To: Chair Lewis and Members of the Portland Planning Board
From: Jean Fraser, Planner
Date: Prepared for: July 12, 2011 Planning Board
Re: **Harborview Townhomes. vicinity 127 York Street**
Request for Reconsideration of Site Plan

Harborview Townhomes
127 YORK STREET (aka 121-129 York Street)
CBL: 44-A-4, 5

Prepared by: Jean Fraser, Planner
Date: July 7, 2011
**Planning Board Report # 13A-11 (Addendum to
PB Hearing Report #13-11)**

Drawing file: Post Approval / Approved parking lot layout and walkway 7.12.2011.pdf

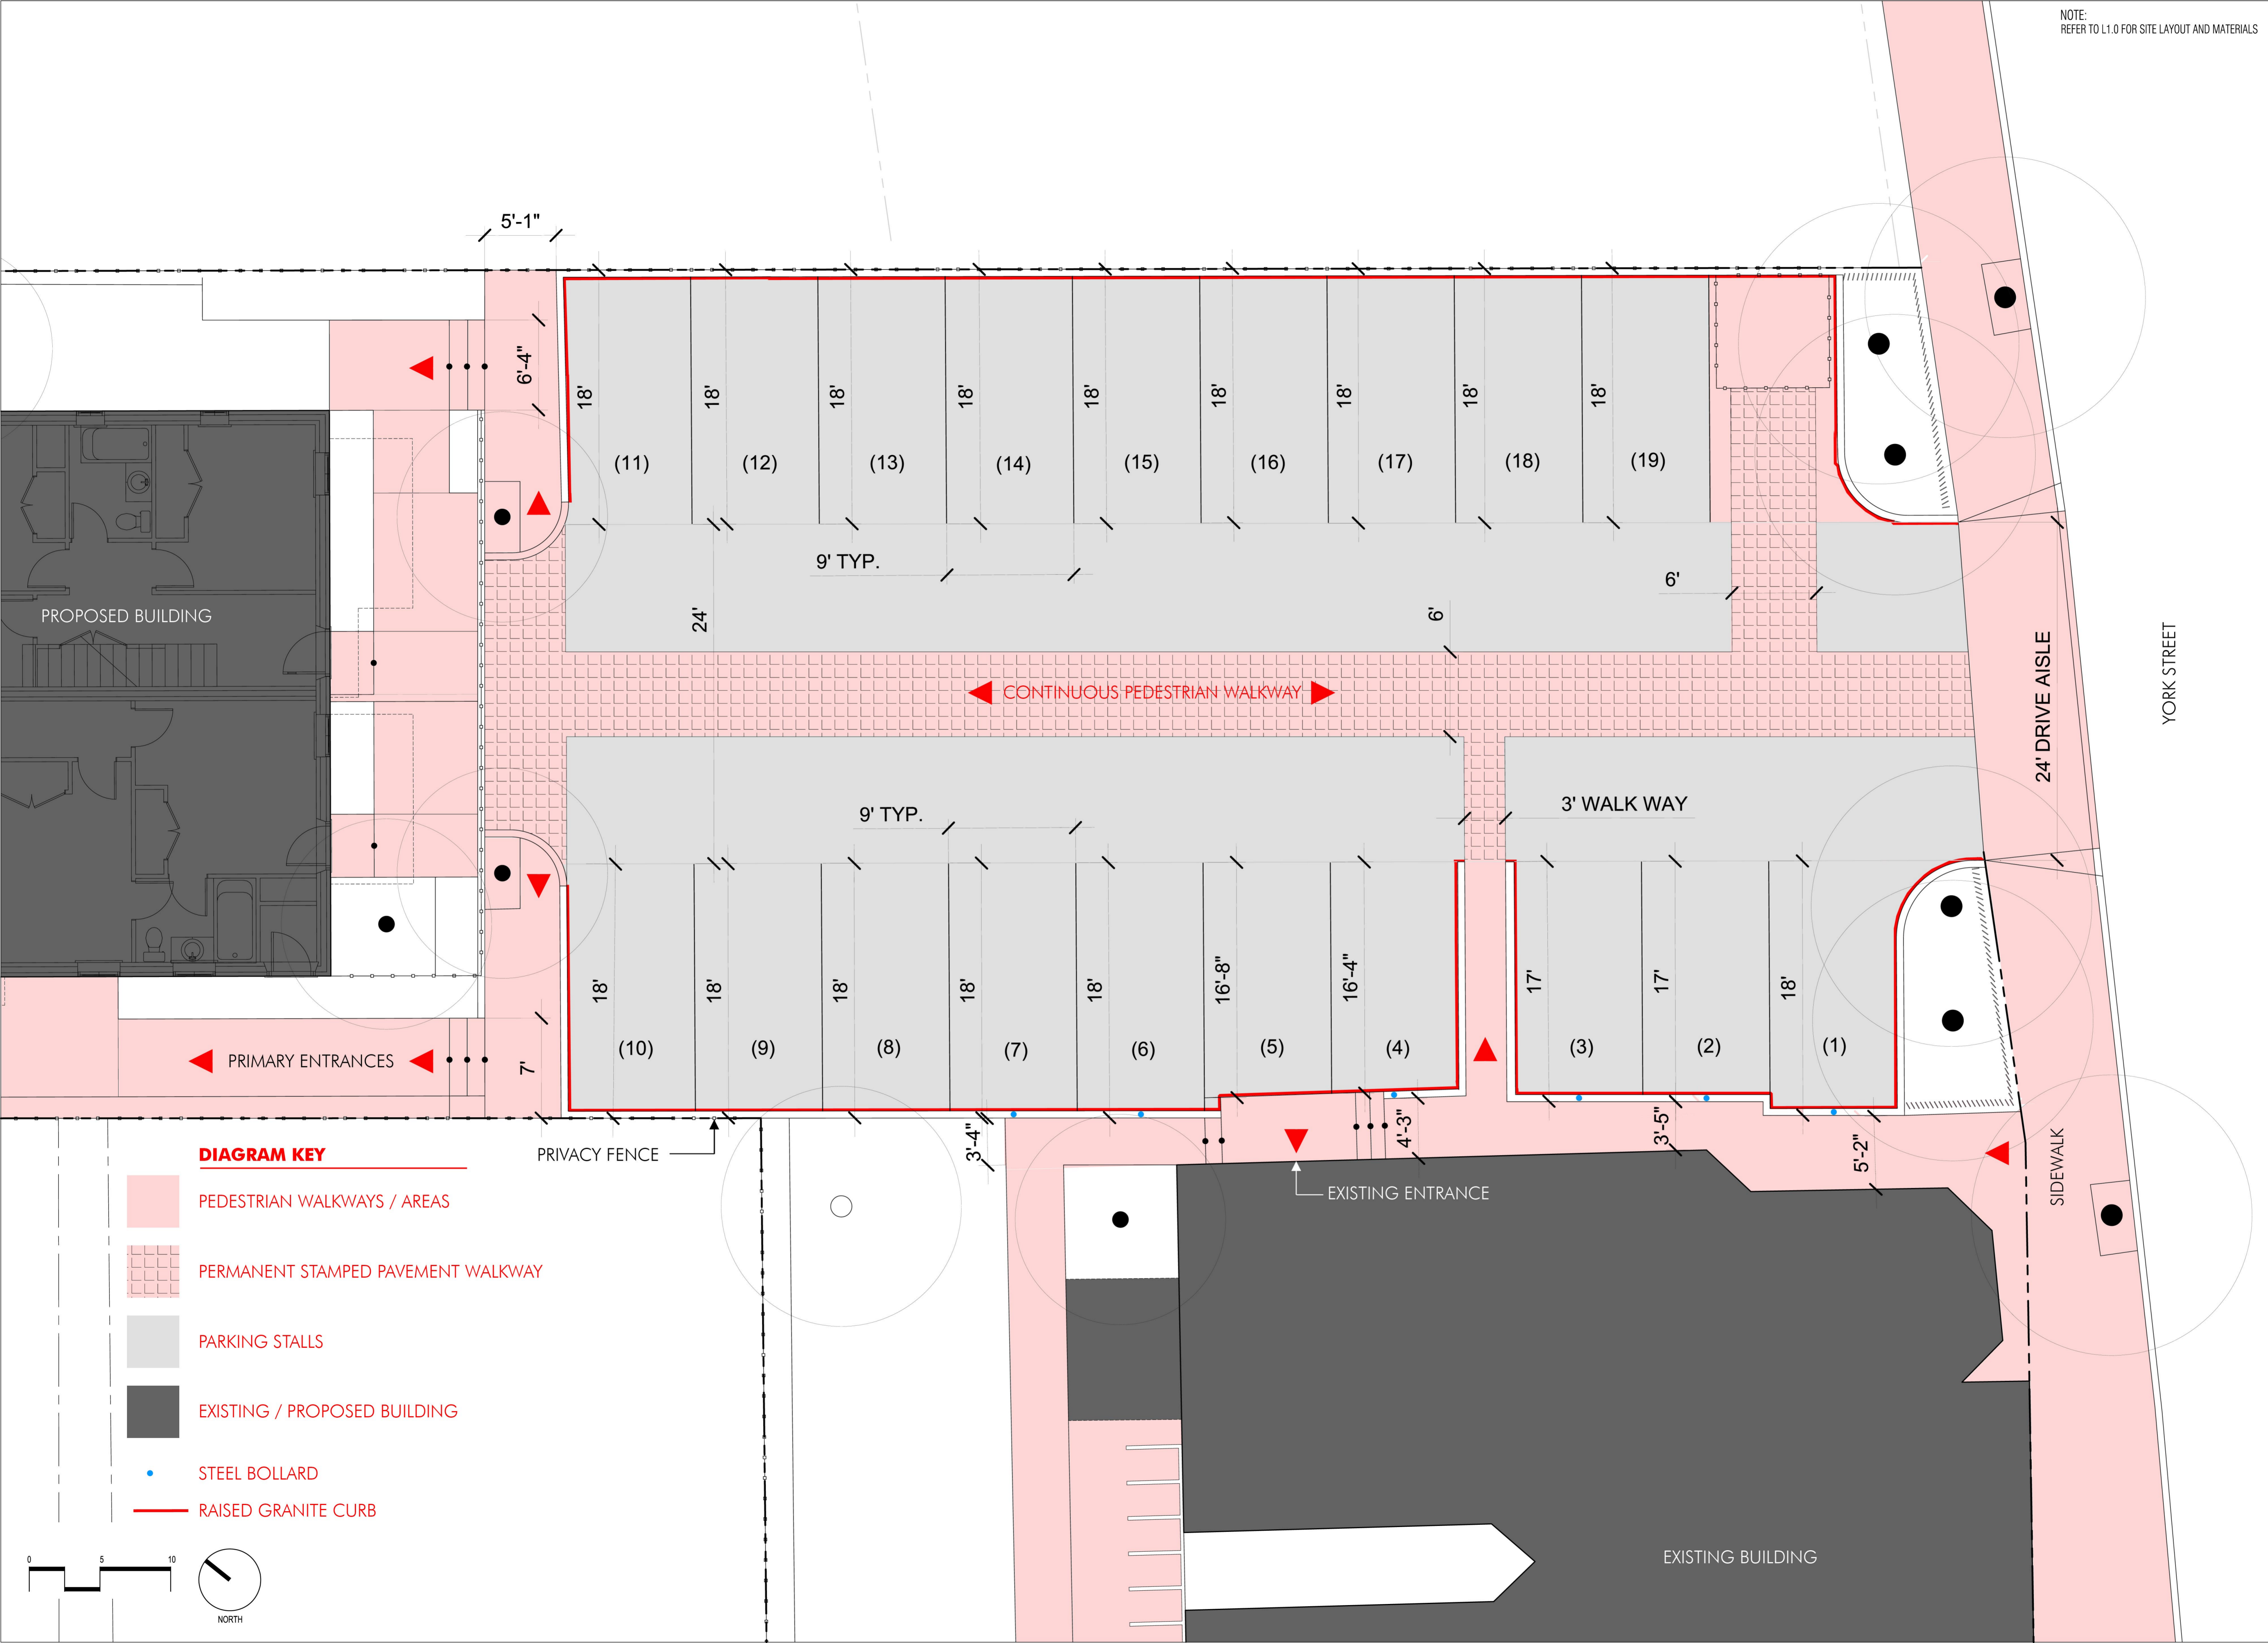
- As shown in Plan "Exhibit B" (Attachment 4, page 5), the pathway specified in condition ii would require the 2 parking spaces nearest the entrance to be 12' 11" in length, almost 2 feet less than the 15 feet required for a compact space and 5 foot less than the 18 feet for a standard parking space;

- The pathway specified in condition ii would require pedestrians going from the public sidewalk to the entrance of the new building to go up 3 steps and then down 2 steps (as this pathway accesses an existing entrance to the existing 12 unit building) before continuing to the back of the site (see "Exhibit B" (Attachment 4, page 5)). It would not be convenient for handicapped persons and the steps would also discourage others from using it.

The applicant has developed a "preferred" option which maintains the parking drive aisle at 24 feet, avoids compact or sub-compact spaces near the entrance and incorporates a continuous internal walkway from the sidewalk to the new building entrance. The walkway is partly through the parking lot drive aisle but the revised layout includes a range of details to create a convenient and direct pedestrian walkway that could be used by handicapped persons. It also is designed to ensure drivers would be aware of pedestrian use of the part within the drive aisle. The applicant's letter describes these details but in summary they are:

- Segregation of the first part of the walkway from York Street sidewalk to the drive aisle using consistent materials and curbing;
- Introduction of bollards and curbing to ensure the cars do not overhang the segregated portion of the walkway;
- Where the walkway enters the parking lot drive aisle it would continue on a stamped (not striped) surface that is visually distinct from the parking lot; [we discussed using the stamped crosswalks as used in Route 1 Falmouth with an embedded white grid pattern];
- The stamped area will link to all other pedestrian facilities and entrance areas;
- The walkway does not involve any steps;
- This walkway design would require 4 of the parking spaces to be compact.

To achieve the revised layout preferred by the applicant, 4 spaces would need to be "compact" as defined in the Technical standards (15 feet by 8 feet). The rest (15 spaces) meet the standard for parking spaces. The Technical Standards allow up to 20% of the parking spaces to be compact where the total is over 10 spaces. In this case the applicant would be allowed $20\% \times 19 = 3.8$ spaces.

plans to incorporate the revisions outlined in the applicants letter and attached “Exhibit B” (Attachment 4, page 5) (the applicant’s preferred option with the walkway partly within the parking lot drive aisle), and approve the associated waiver allowing a total of 4 compact spaces.

- New ii That the applicant shall submit revised site plans to incorporate the pathway route and associated revisions as shown in the submitted plan “Exhibit B” (Attachment 4, page 5) dated 7.5.2011. for review and approval by the Planning Authority prior to the issuance of a building permit; and
